11 September 2018

SF2017/281844; WST17/00198

**SSD8895: Lots 75-84, 88, 119-121 DP 2987, Lots 1 & 2 DP 1104720, Lot 3 DP 976701, Lots 1-3 DP 808748, Lot 100 DP 750760, Lot 1 DP 1206579 and Lot 1 DP 664645
Goolma Road (MR 633), Wellington; Wellington North Solar Farm; Environmental Impact Statement**

The information provided in the EIS is inadequate and in some areas, conflicts with other statements made elsewhere in the EIS. Roads and Maritime, at this time, withholds its advice to the Department. To enable Roads and Maritime to complete its assessment of SSD8895, the following additional information is requested:

Figure 2 Haulage Route as described in the Traffic Assessment for Wellington North Solar Plant

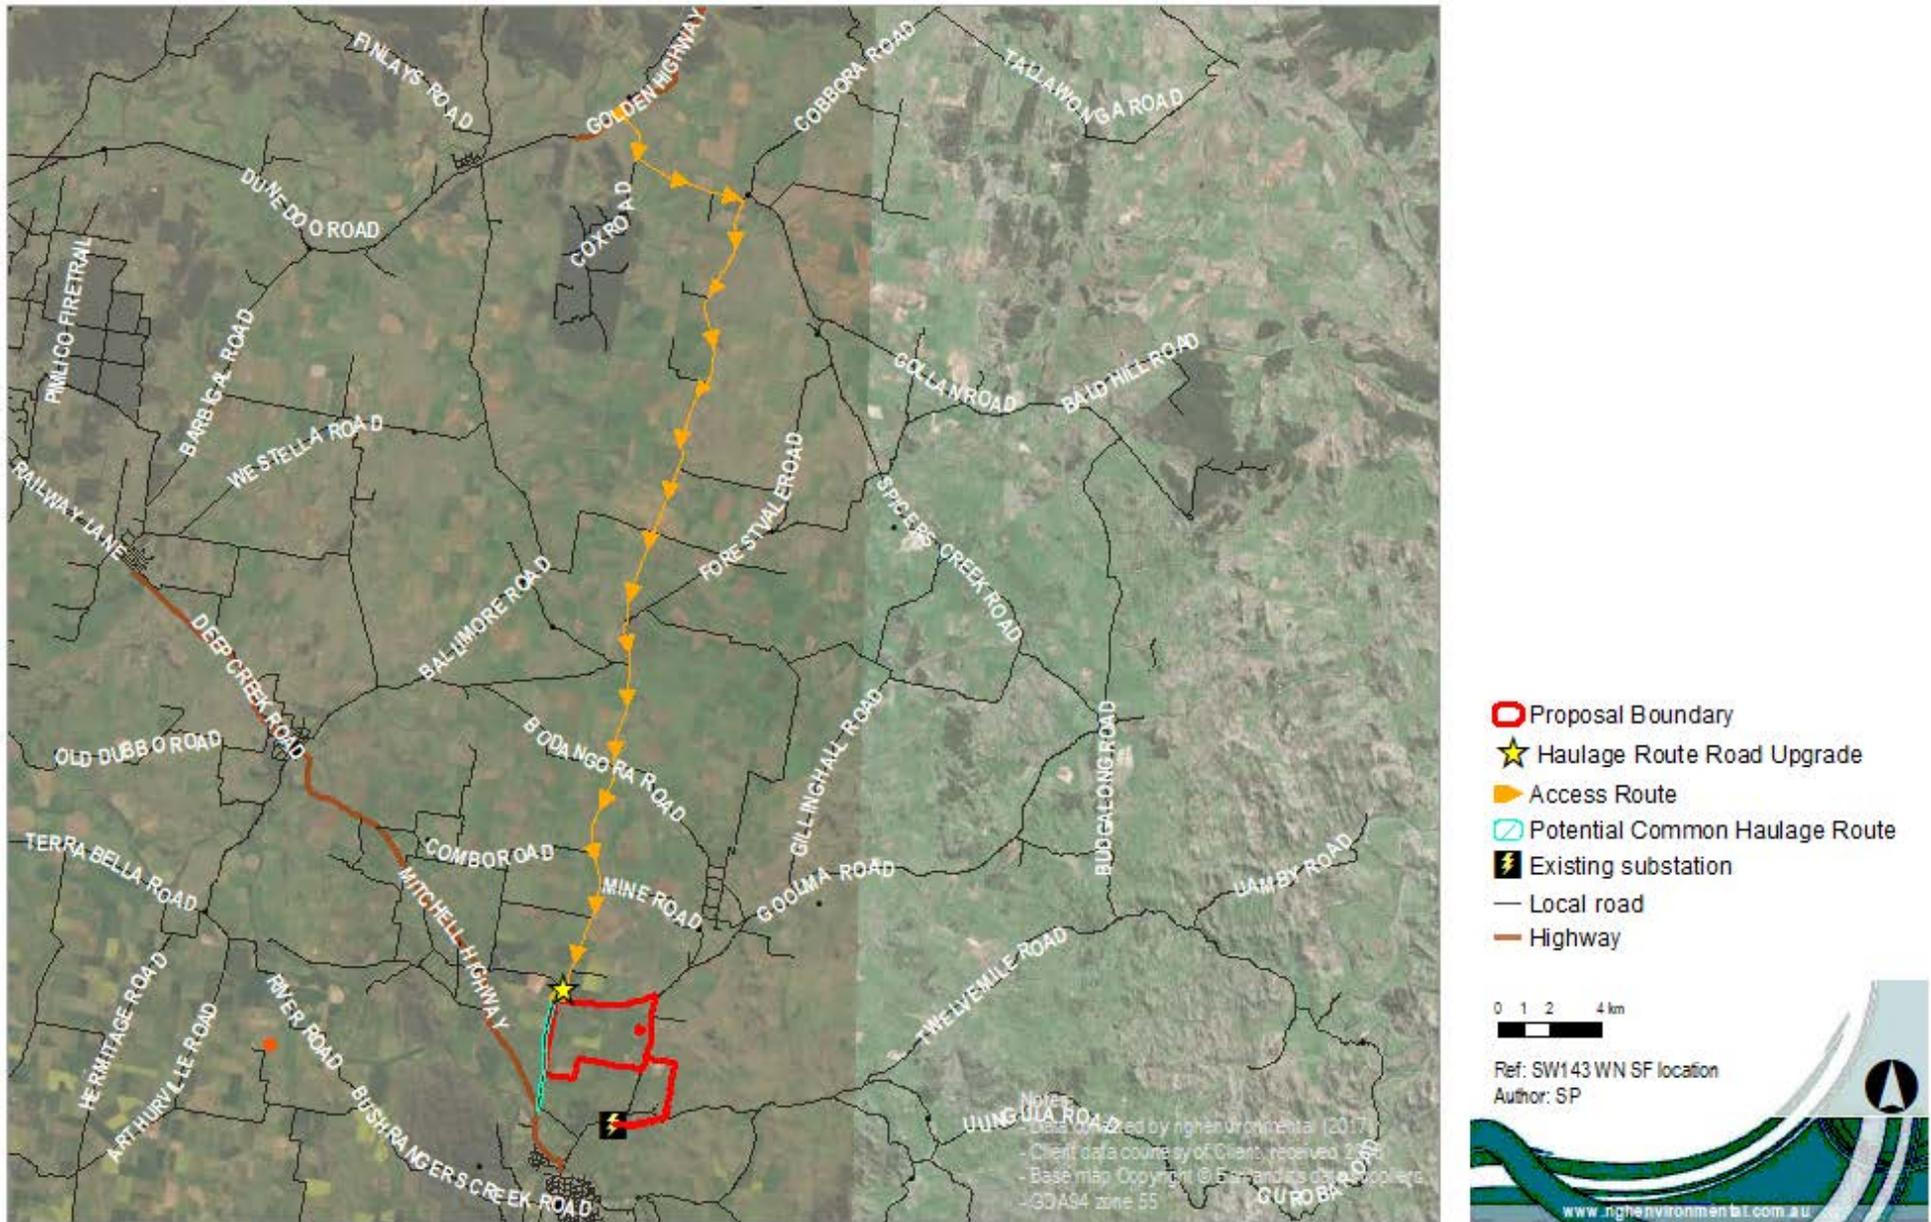
- The EIS assumes all vehicular access from Campbells Lane will be via Cobbora Road. Details of how vehicular access to the site will be obtained from Campbells Lane via Cobbora Road (MR353) only and not also from Campbells Lane via Goolma Road is required. Should the applicant not be able to demonstrate how vehicular access from Campbells Lane will be via Cobbora Road only, an assessment of the traffic impacts at the Campbells Lane/Goolma Road intersection is required.
